Fire Marshal Division

**Re: University Storage, LLC
E. Stewart St.
Coats, NC 27521**

**Application Number BCOM1911-0002 (Building 1)
BCOM1911-0003 (Building 2)
BCOM1911-0004 (Building 3)**

LIFE SAFETY PLAN BUILDING 2"

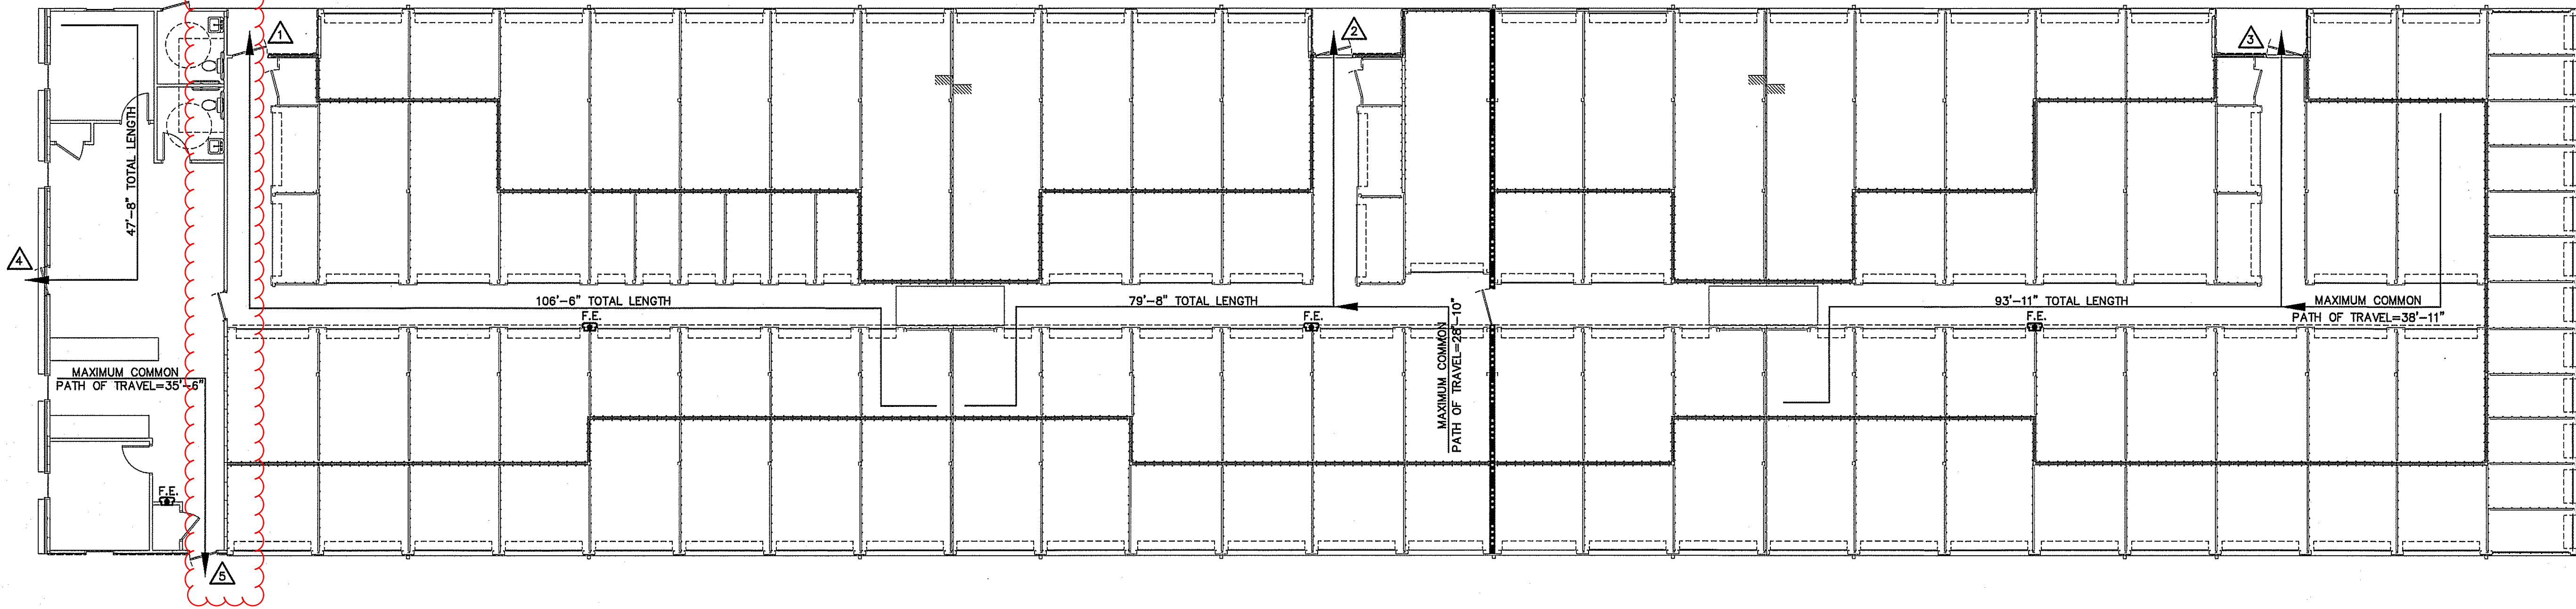
- **Rated Walls**
 - A 2-hour rated wall should separate the Office space and the S-1 space. See plan markup for details.
- **Please schedule fire final inspection through the Fire marshal's office at 910-893-0742**
